OBJECTION TO PLANNING APPLICATION

Application reference: 2026/62/92200/E

Site: Scholes Cricket and Athletic Club, New Popplewell Lane, Scholes, Cleckheaton, BD19 6NN

Proposal: Formation of two outdoor padel courts and associated works

PLAN OF PADEL COURT

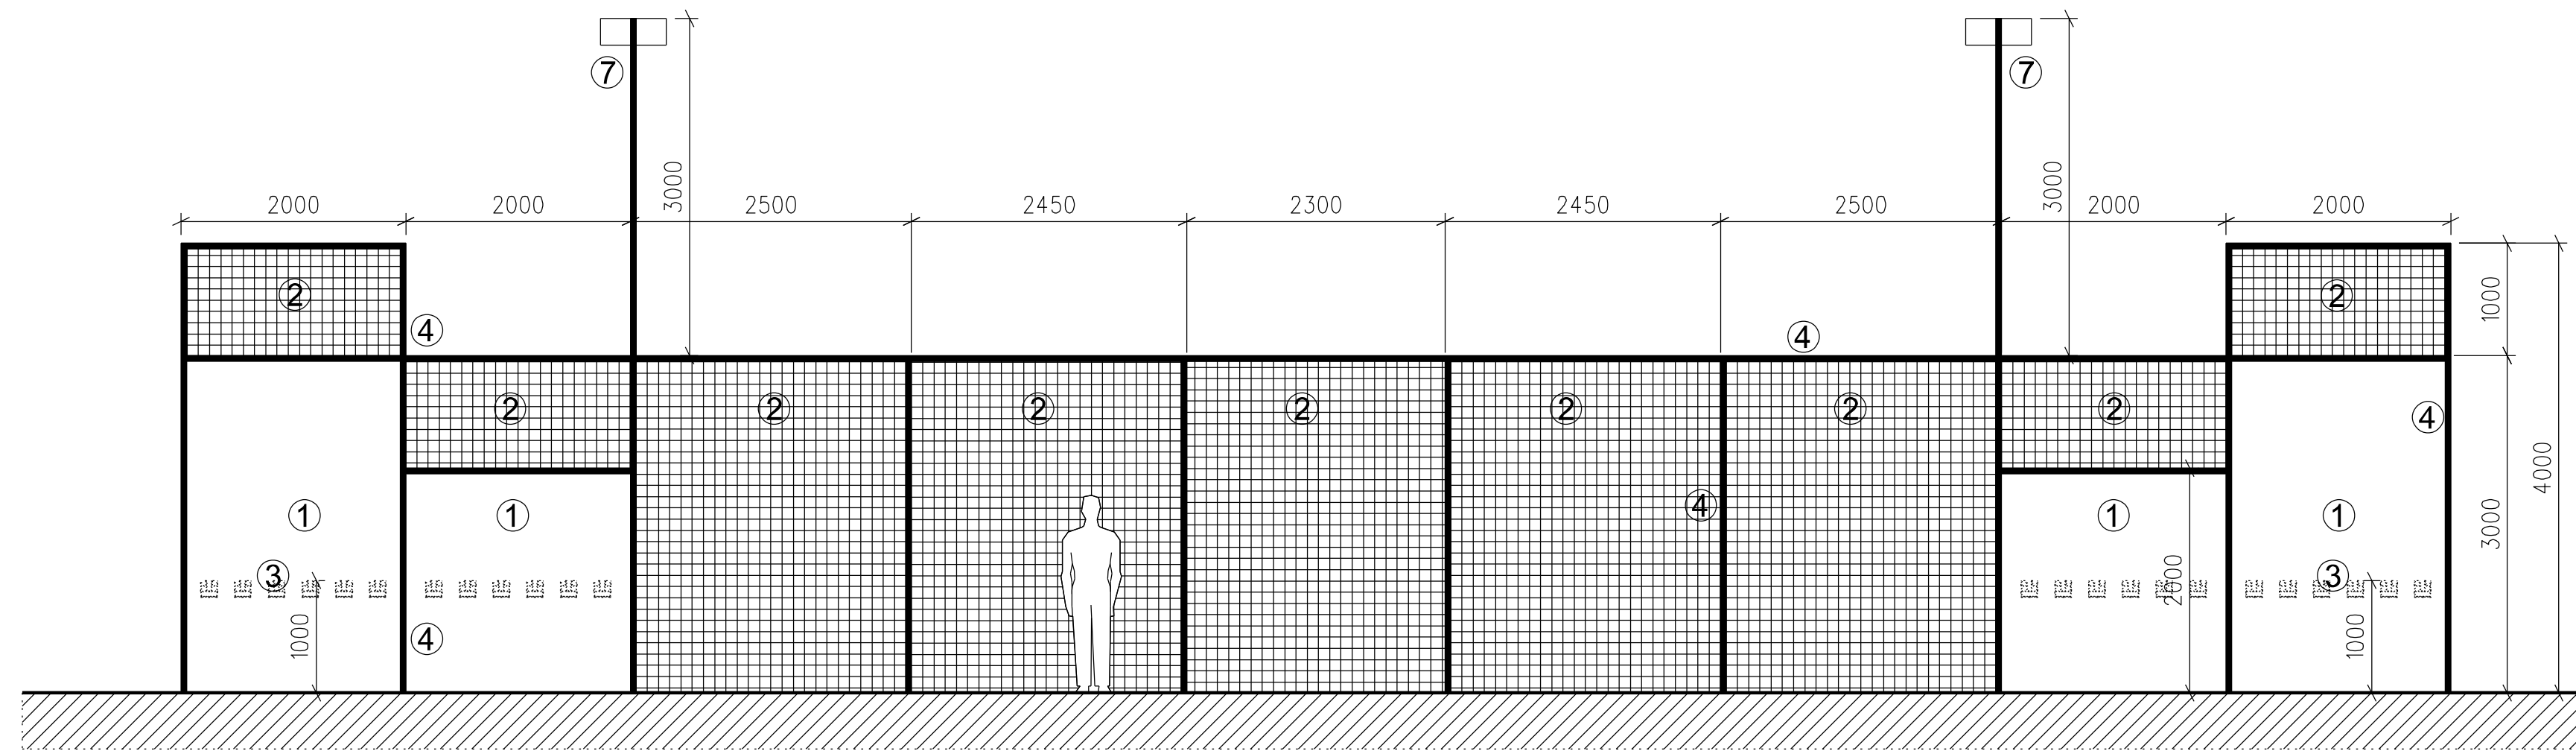
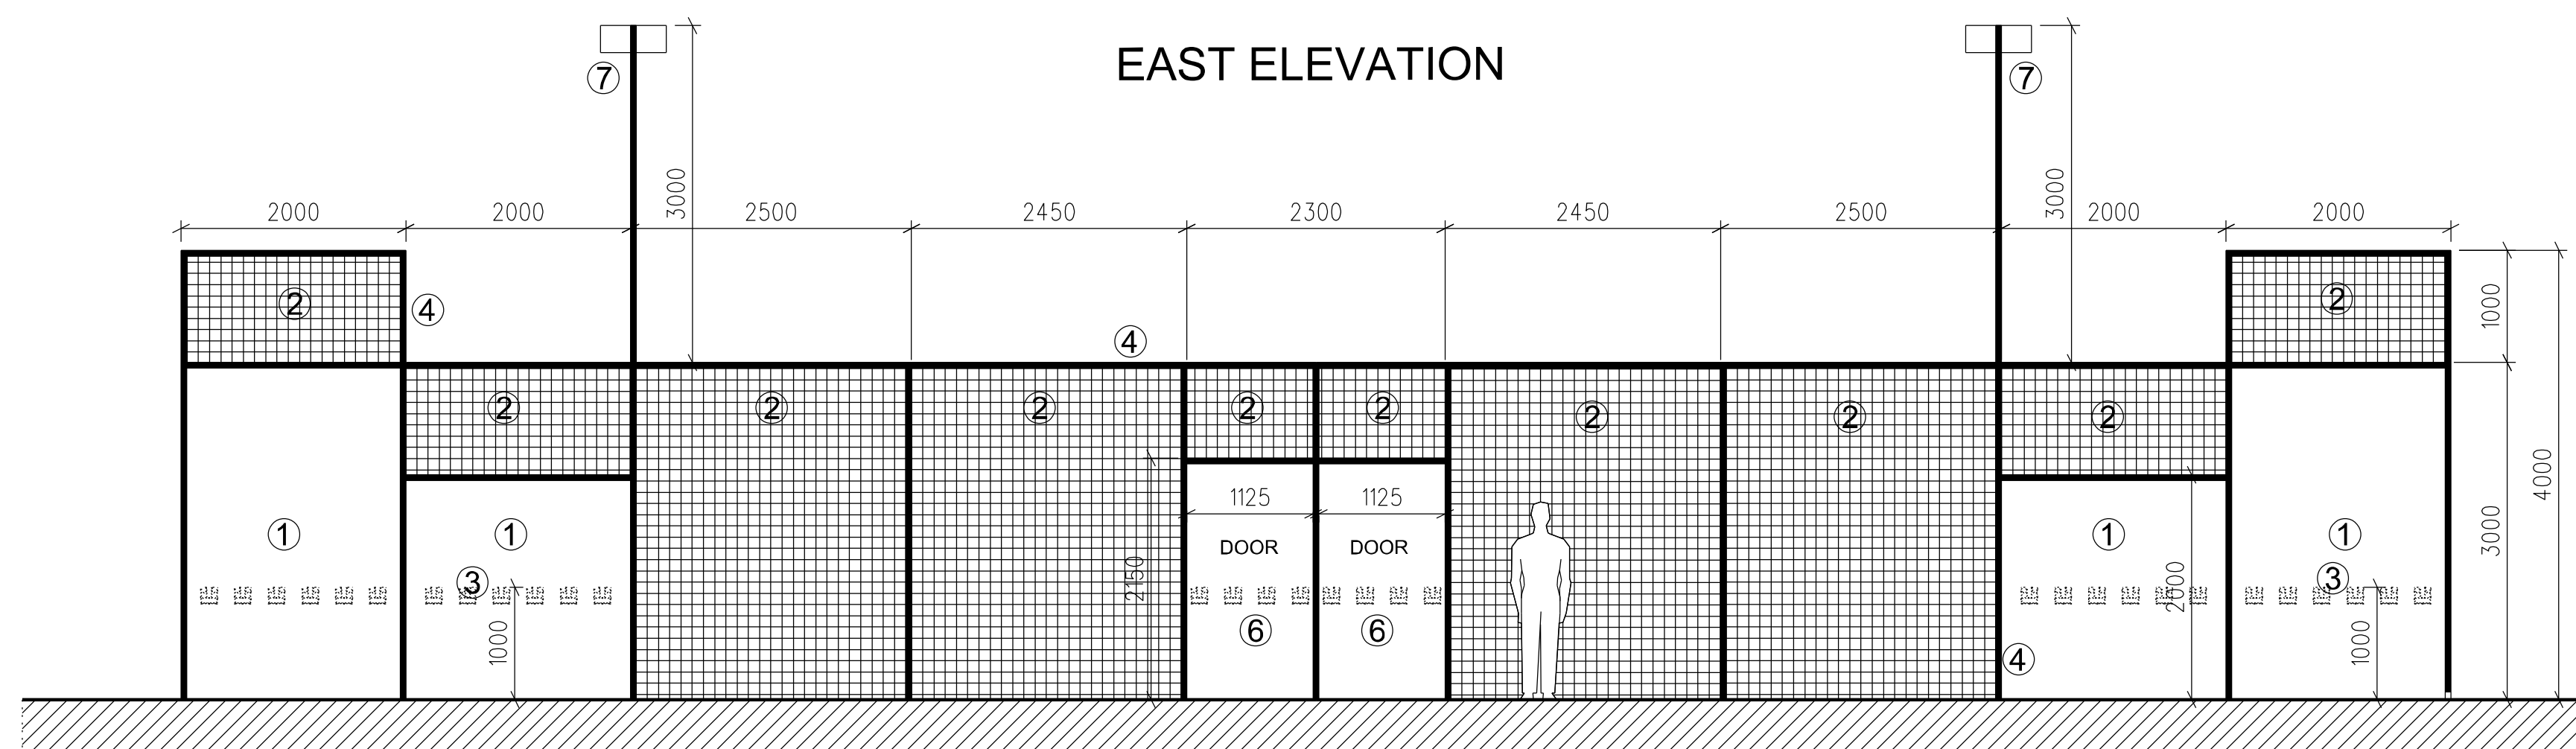
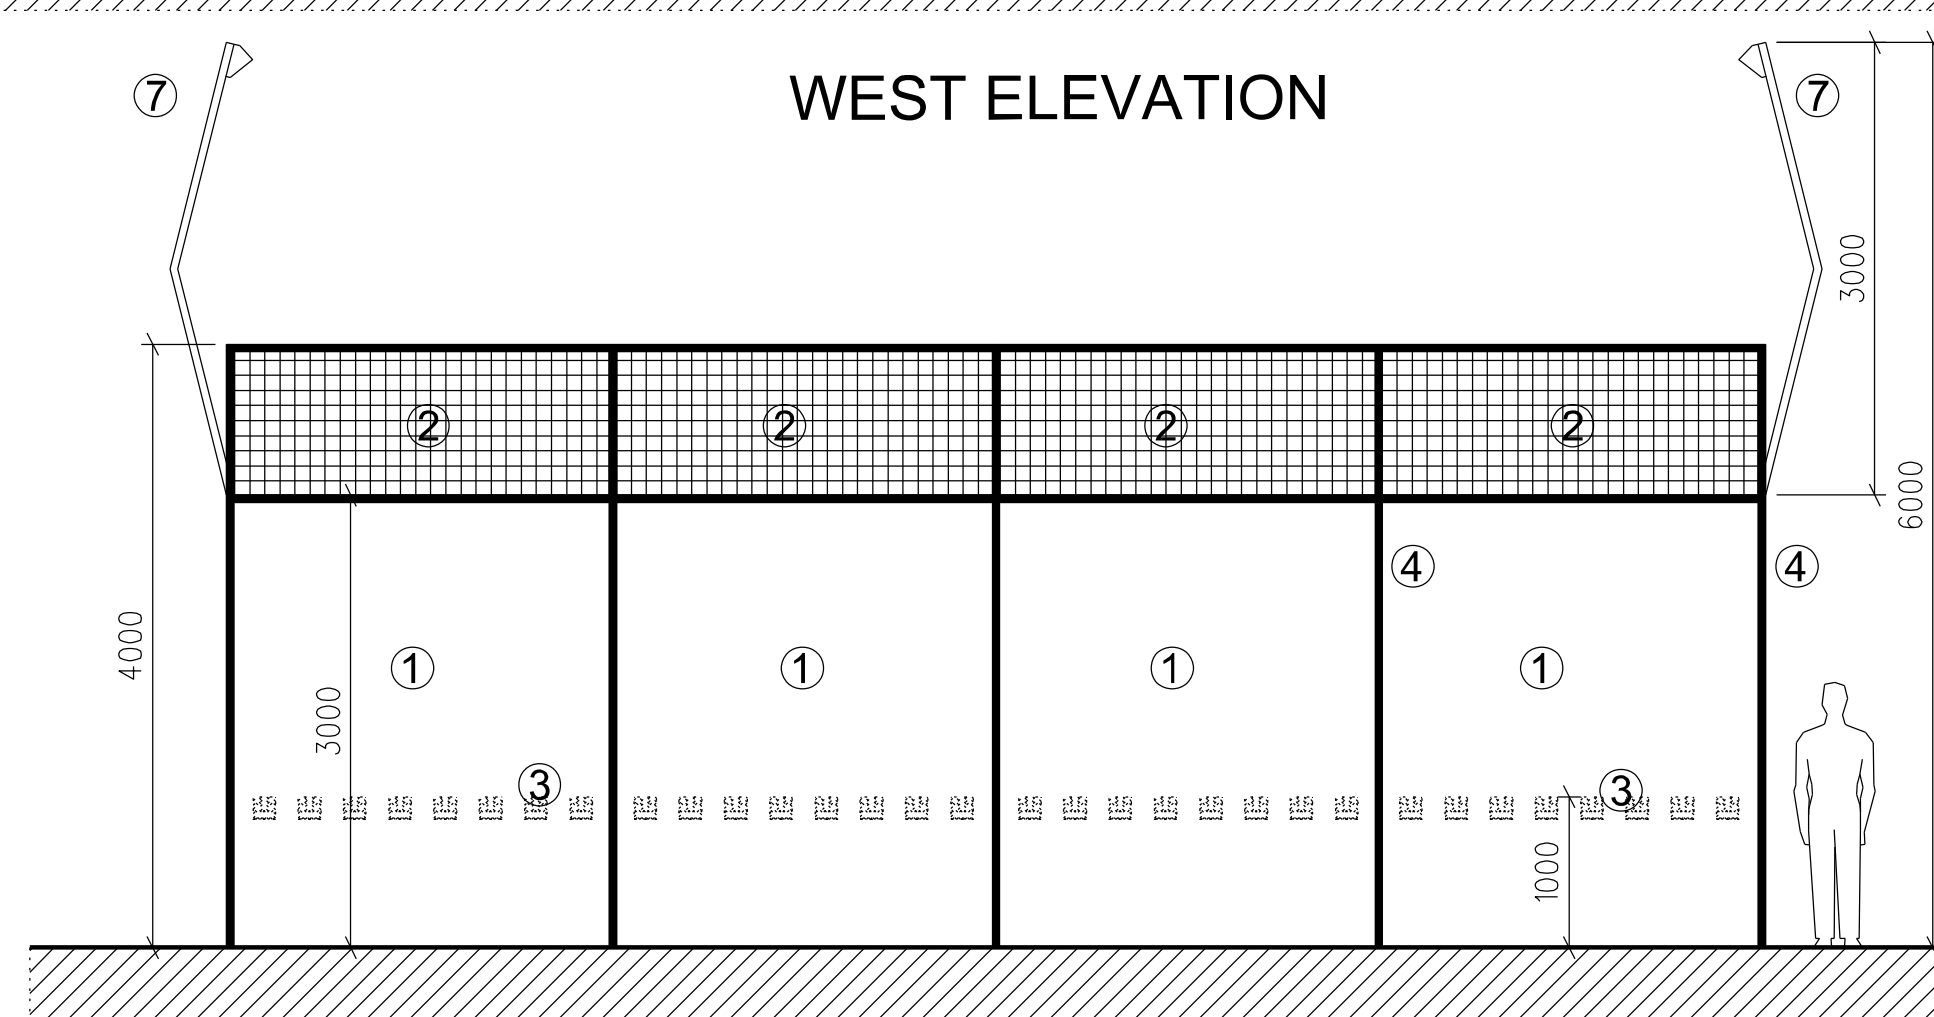
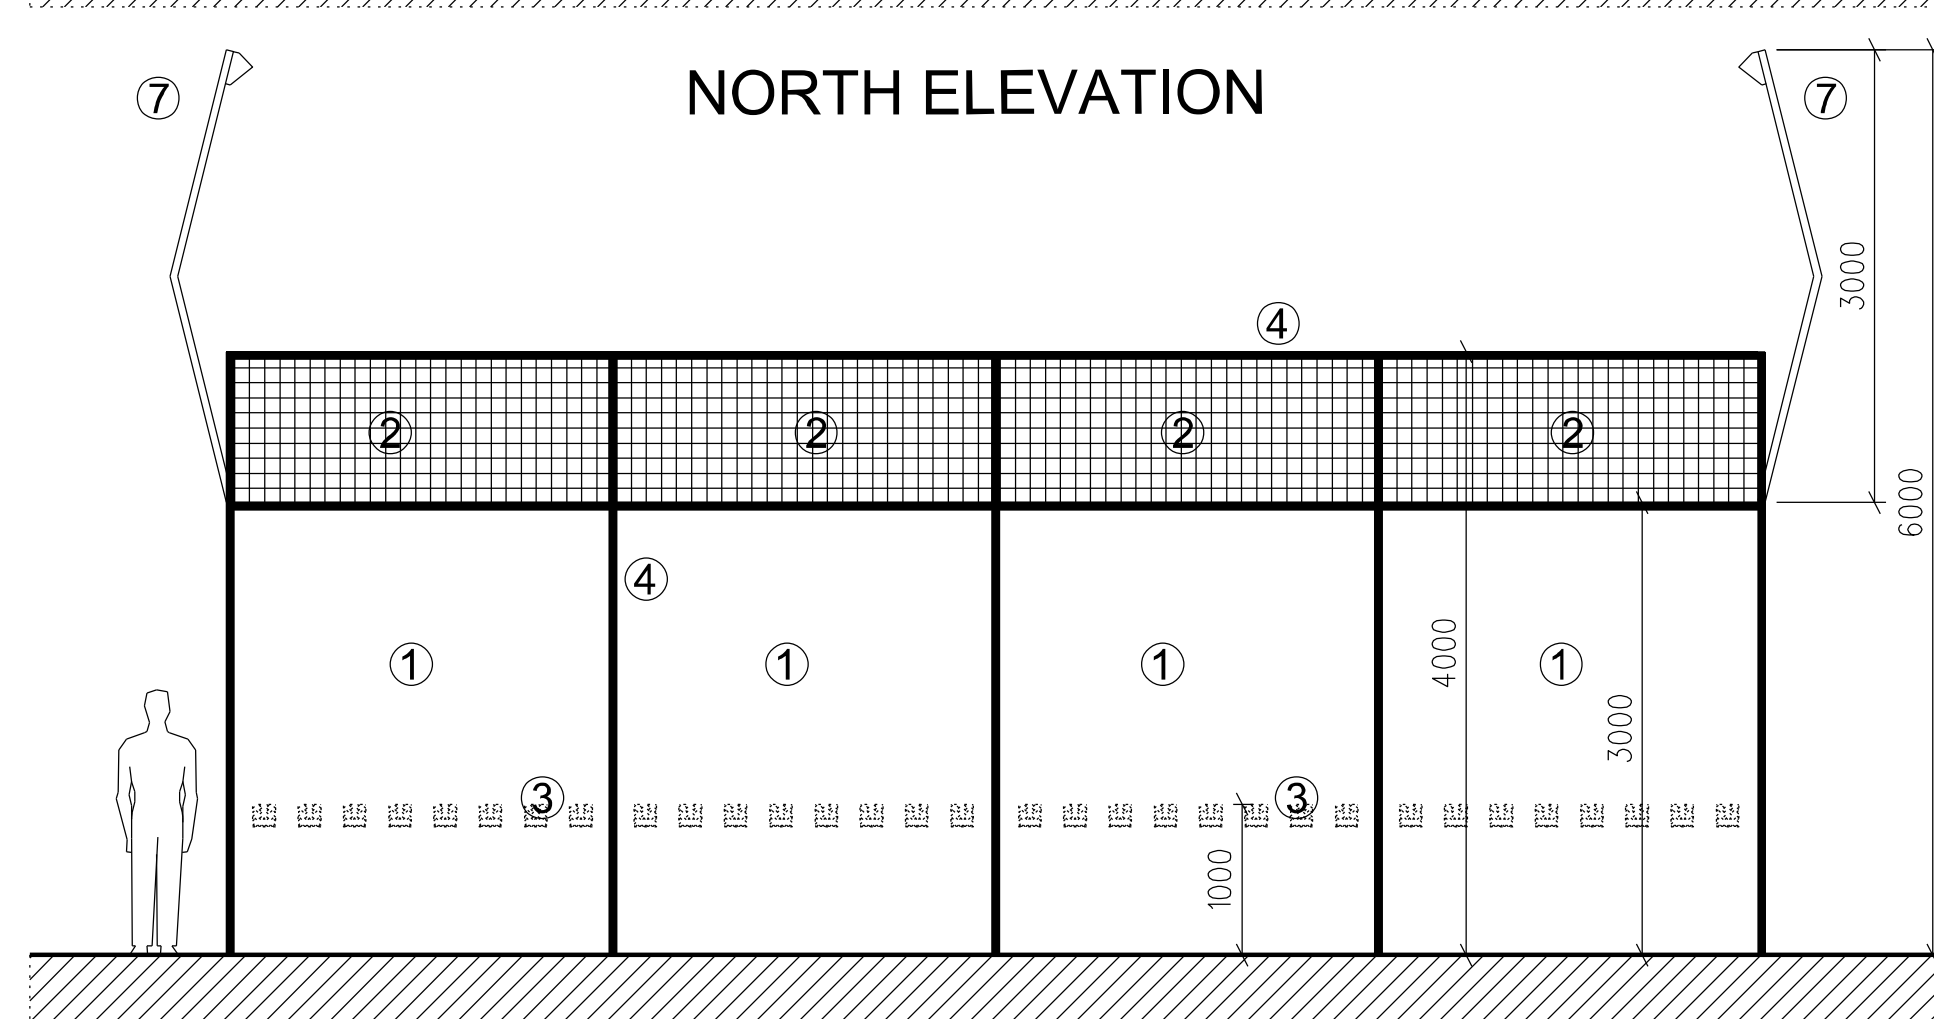
- PDAS paragraph 3.5: *"Floodlights would also be installed."*
- The Padel Court Plan & Elevations (drawing 1155315, Revision A), where legend item 7 reads *"FLOODLIGHTING TO SPECIALIST'S DESIGN"*.

The drawings show four lighting columns per court — eight in total — at **6 metres** in height, with luminaire heads projecting above that. There is no luminaire specification, no photometric data, no isolux or light-spill contour drawing, no predicted vertical illuminance at any residential window, no upward light ratio, no glare assessment, no colour temperature, and no proposed control or curfew arrangement.

- **Height of the development.** PDAS paragraph 3.4 states "*The height of the courts is 4m at its highest.*" The submitted elevations show 6m lighting columns. The tallest element of the development is understated by 50% in the document the Council will rely on for its visual amenity assessment.
